Thank you for your application for the discharge of planning conditions which was deemed as valid on the 10th August 2023. I have given consideration to the information submitted and have the following comments to make:-

#### Condition 8 - Large Scale Joinery Details

Drawing Title
WINDOW DETAILS

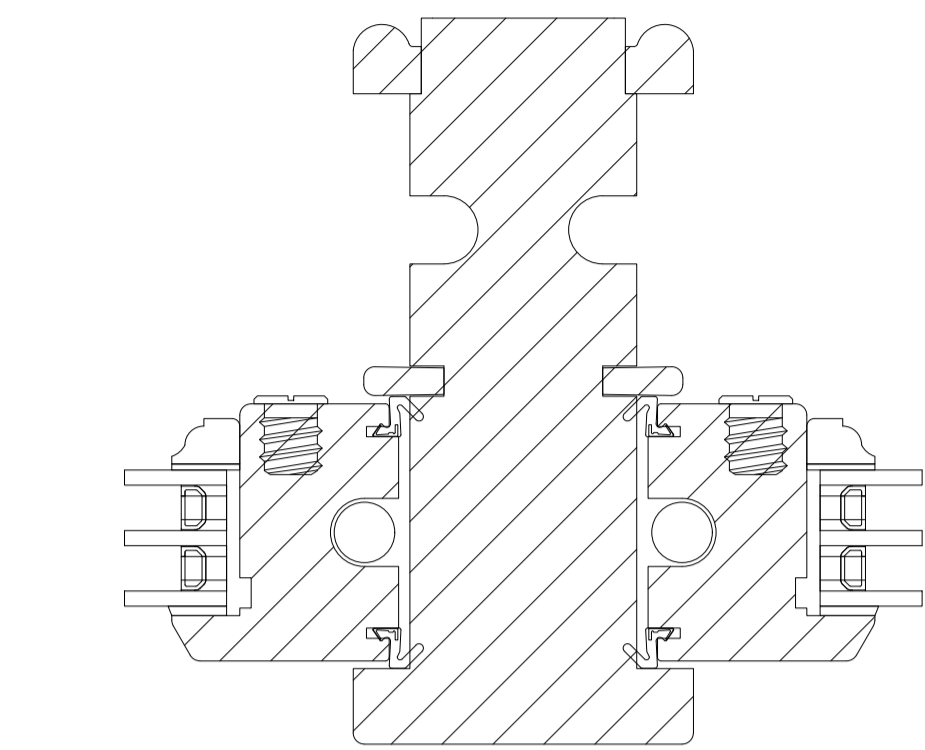
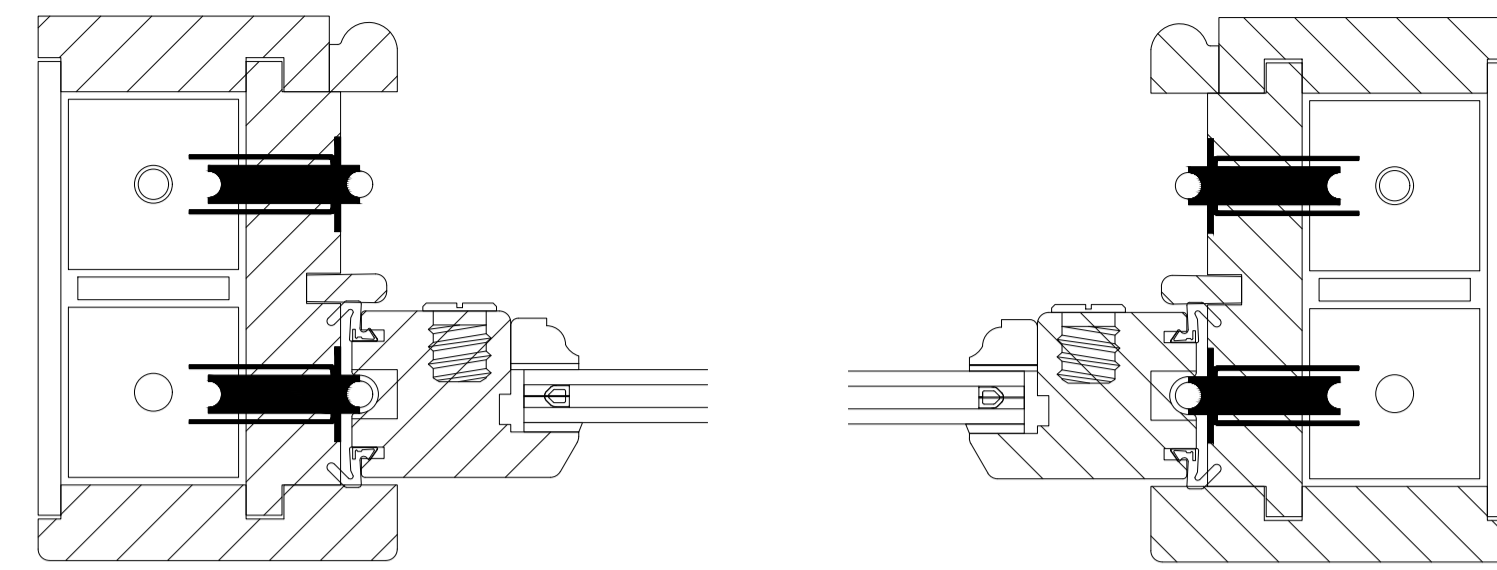
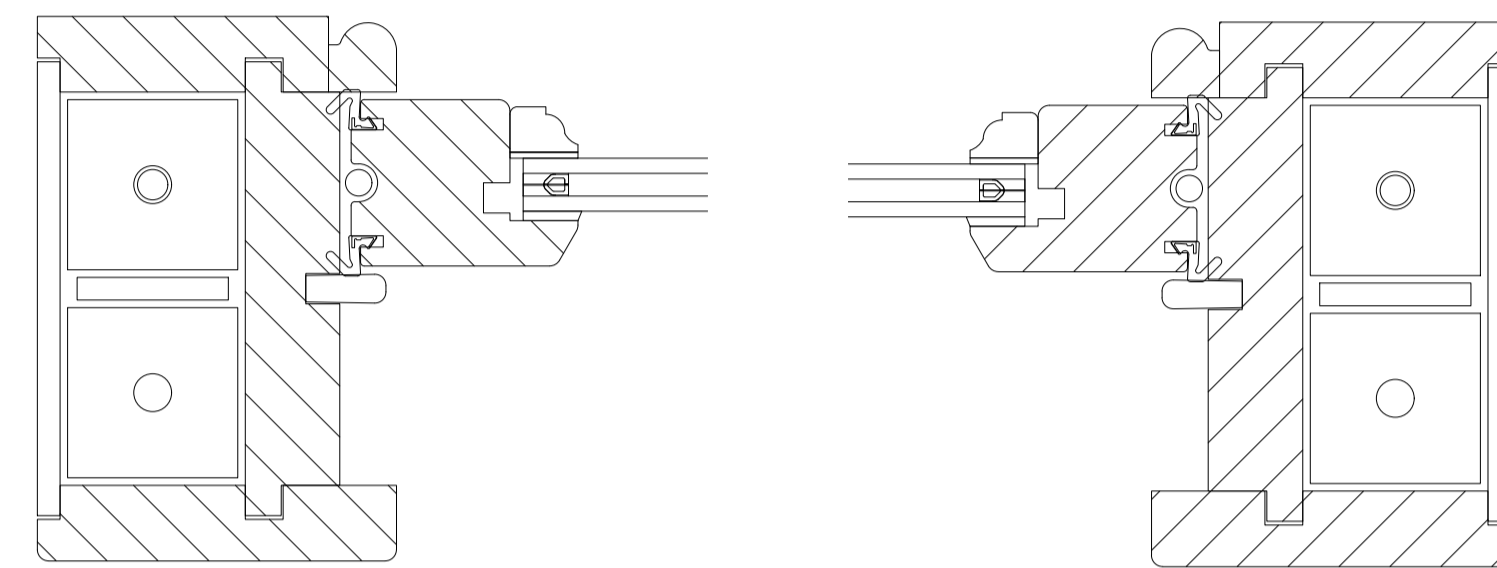
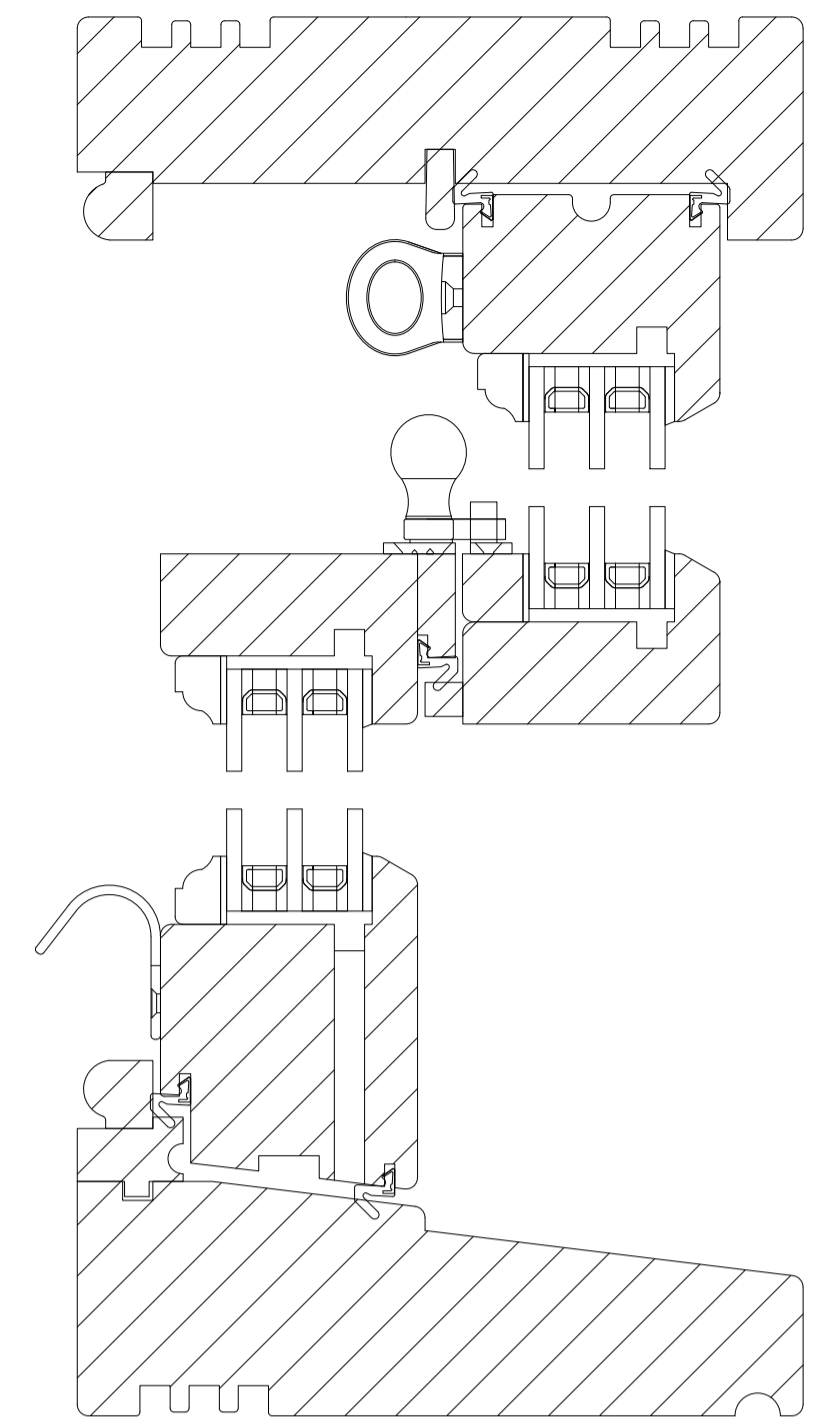
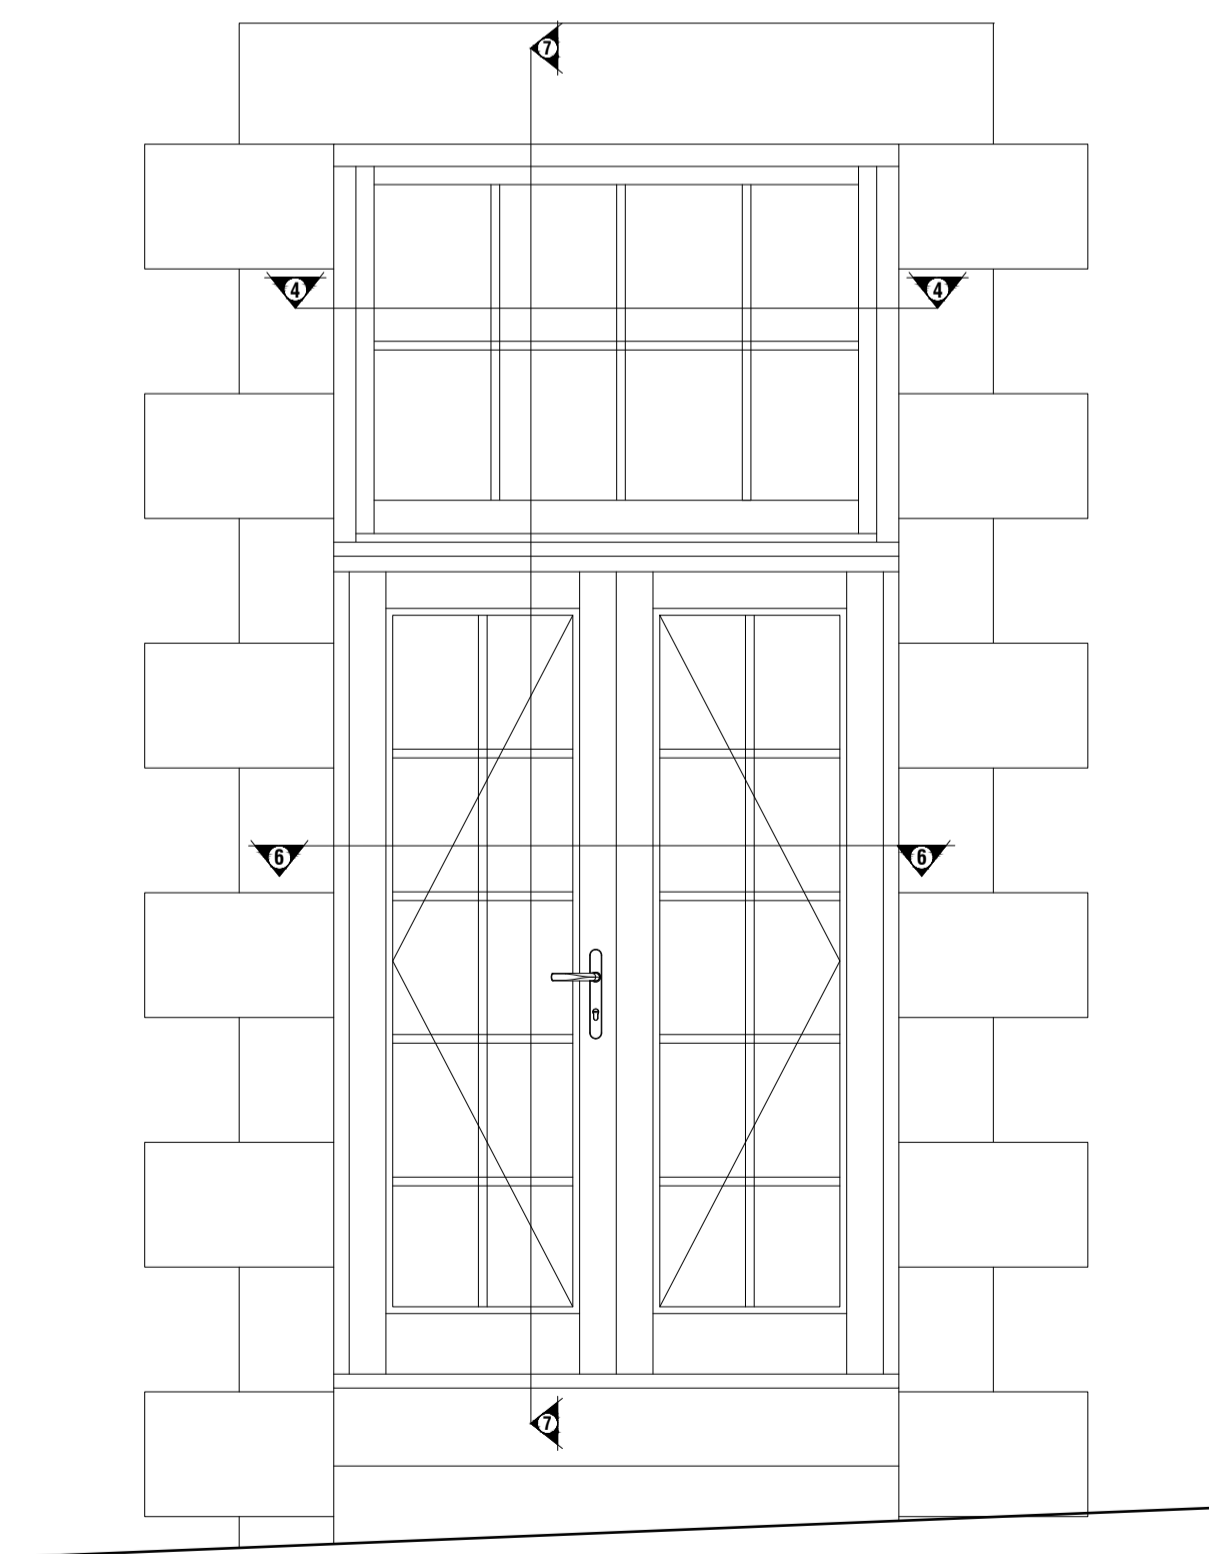
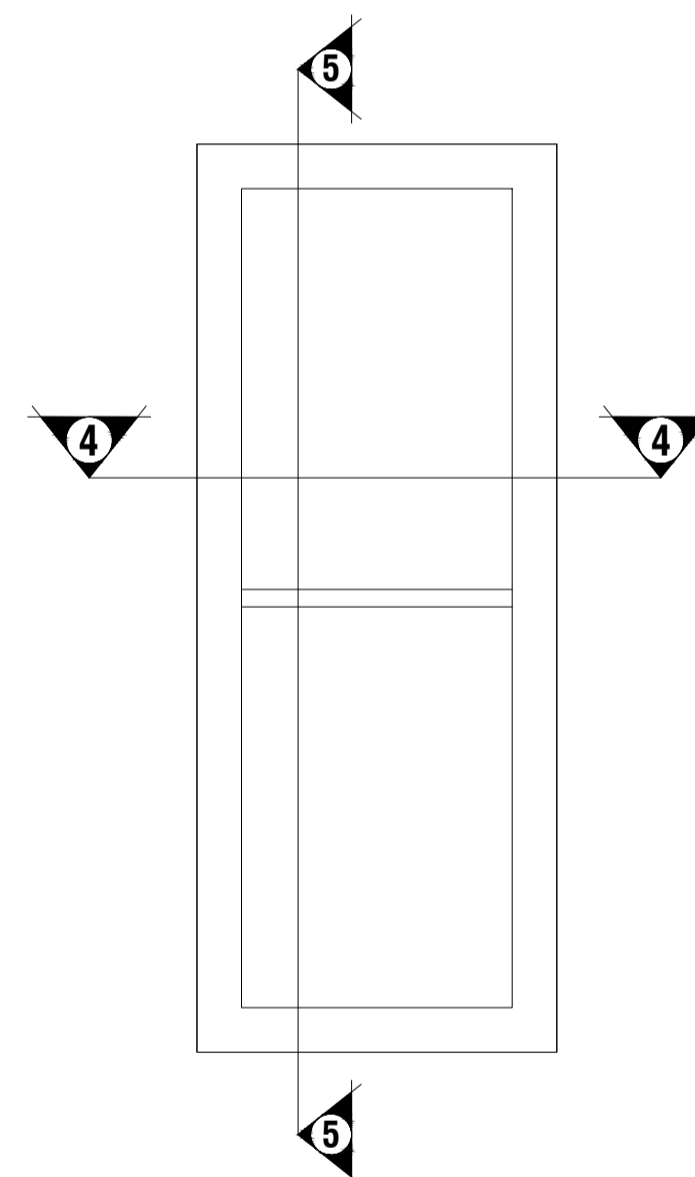
Comment: I can confirm that the information submitted is NOT acceptable. The Council's Built Heritage & Design Officer has reviewed the submitted details and cannot support the use of unsustainable and inappropriate uPVC on the heritage asset. This would not be in the interests of the building and would not accord with Policy ENV 7 that seeks to conserve and enhance the significance, quality and integrity of Northumberland's heritage assets. Due to insufficient information and the proposed design and materials of the windows and door, Condition 8 is NOT discharged.
